2024/0712

Land to the south of Unit 1 and 2 Old Mill Lane, Barnsley.

Installation of 1 x 48 sheet digital free-standing LED illumination advertising display panel.

**Recommendation –
Refuse**

Title
Proposed Site Plan

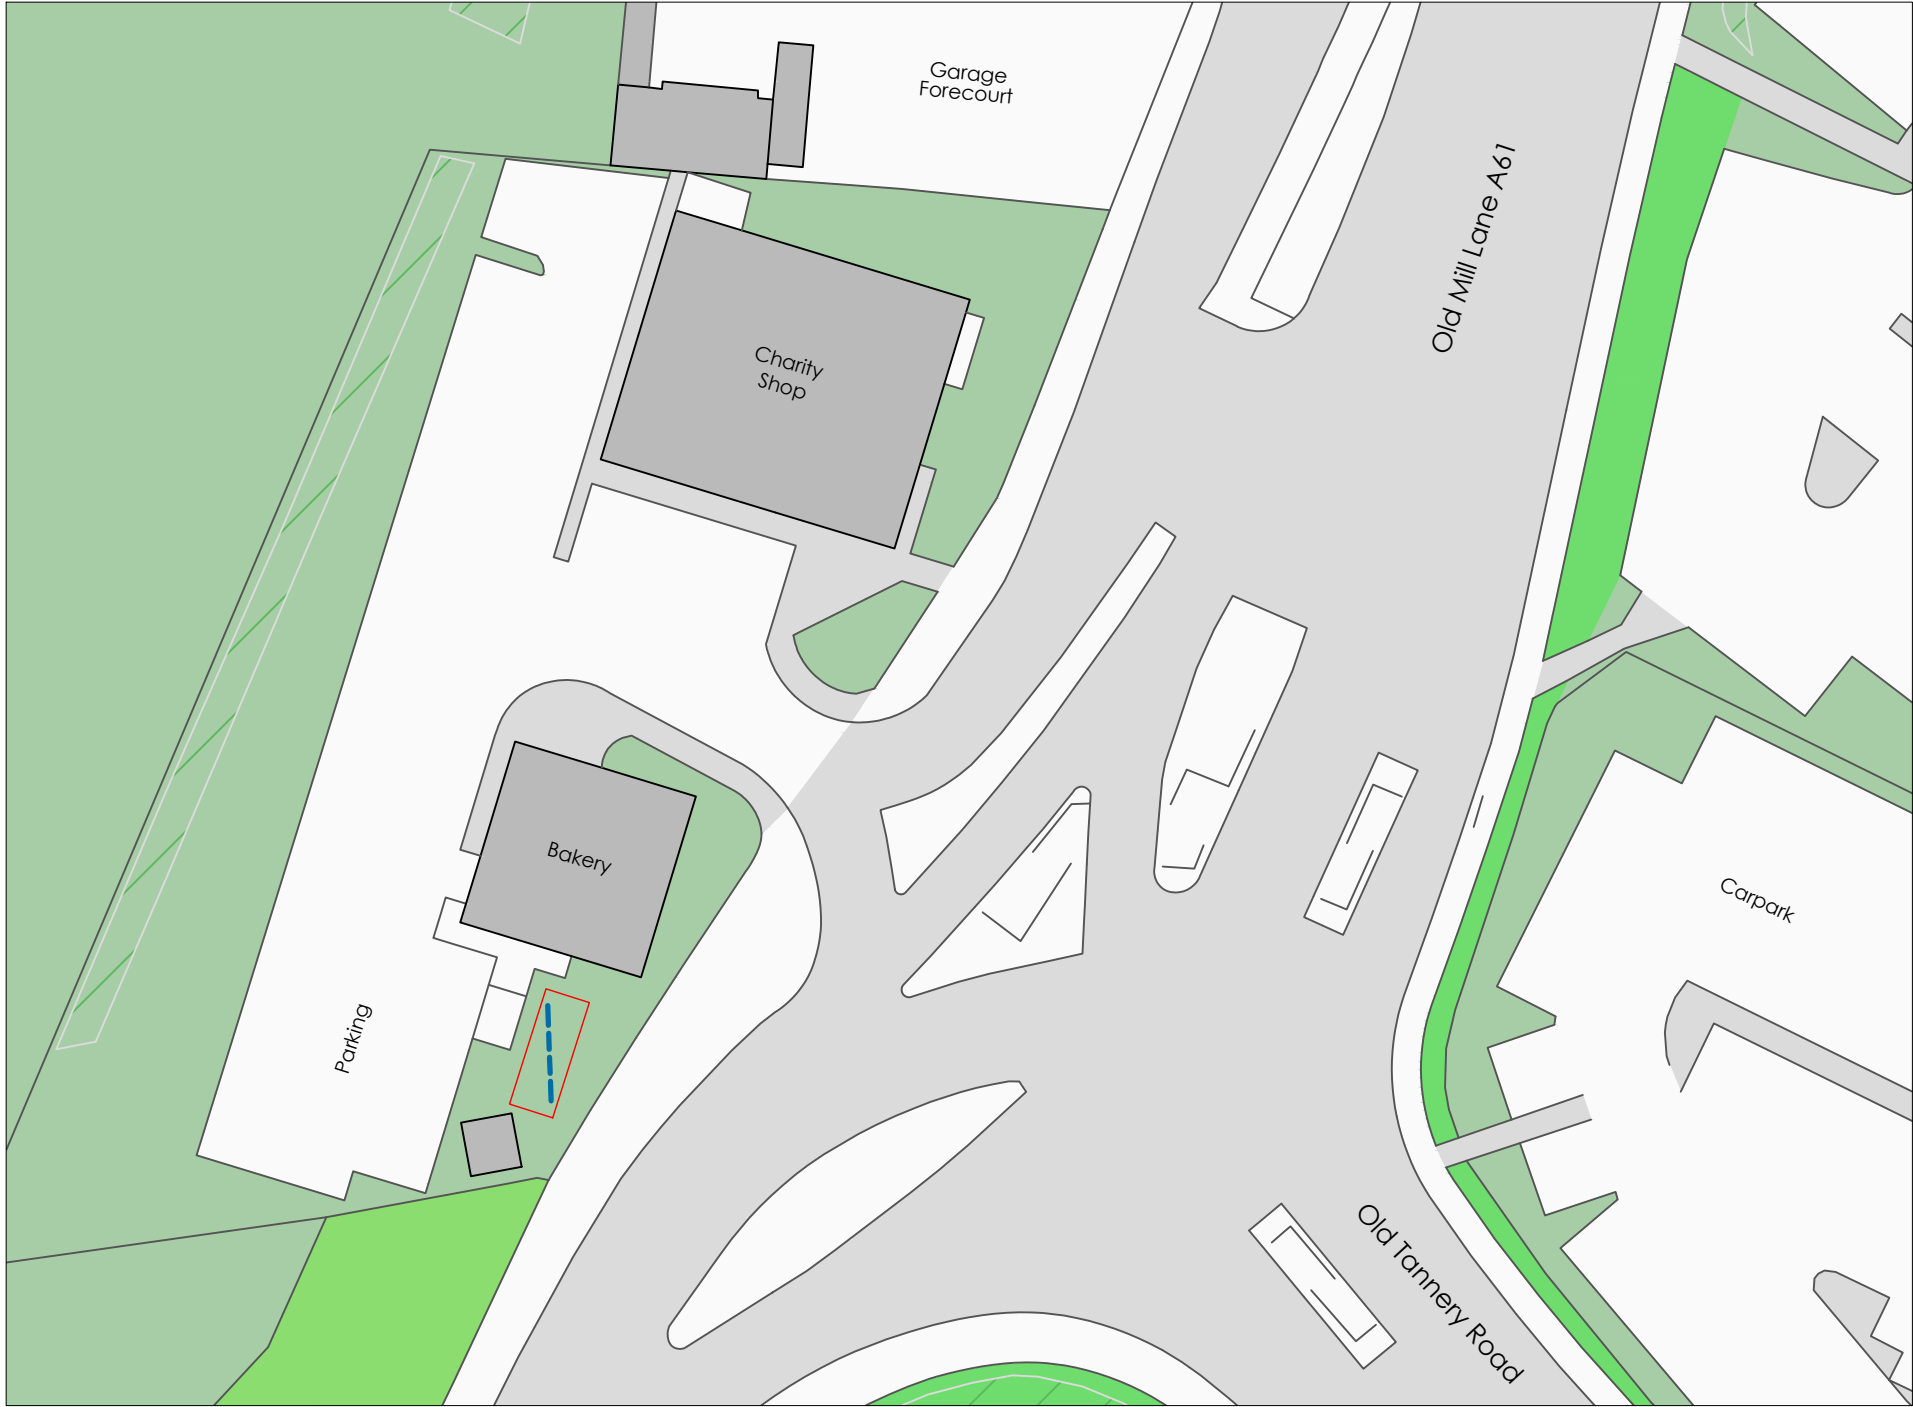
It is accepted that the surrounding area is predominantly commercial, and that the installation of a free-standing digital display panel would not necessarily be out of keeping with the character of the area, especially in the context of existing free-standing digital and paper display panels and a variety of other signage. However, it is considered that the proposal would contribute to unacceptable cumulative impacts in that the proposal would lead to an oversupply of such panels in a relatively concentrated area and could give rise to a cluttered and aggressively commercial appearance. It is acknowledged that some separation would be maintained between panels and some screening could be provided by the adjacent commercial unit. However, it is not considered that this would act as sufficient mitigation, and the increase of free-standing digital display panels in the area could give undue dominance and prominence to such development in the street scene and detract from the overall quality of the area. The extent of any potential screening would likely be limited to southbound traffic with views of the display panel being much more visible from Old Tannery Road and to northbound traffic along Old Mill Lane.

Development works are ongoing to widen Old Mill Lane to the south of the signalised junction which has involved the removal of trees that has subsequently opened the space and reduced the overall level of screening surrounding the application site. As such, the proposed digital display panel would appear as a prominent feature in the street scene, and although its orientation could provide some mitigation, the height of the display panel would exceed the eaves height of the adjacent commercial unit and would therefore appear as an overtly and visually domineering structure.

The proposal is therefore considered to be contrary to the principles outlined in the *Advertisements SPD* and *Local Plan Policy D1: High Quality Design and Placemaking* and would be unacceptable regarding visual amenity.

In the opinion of the Local Planning Authority, the proposed advertisement would materially harm the appearance of the street scene by reason of its size, siting and undue prominence, and would result in the oversupply of digital display advertisements in a concentrated area leading to the over-commercialisation and dominance of the locality. The proposal is therefore considered to conflict with Local Plan Policy D1: High Quality Design and Place Making, the Supplementary Planning Document: Advertisements and the National Planning Policy Framework.
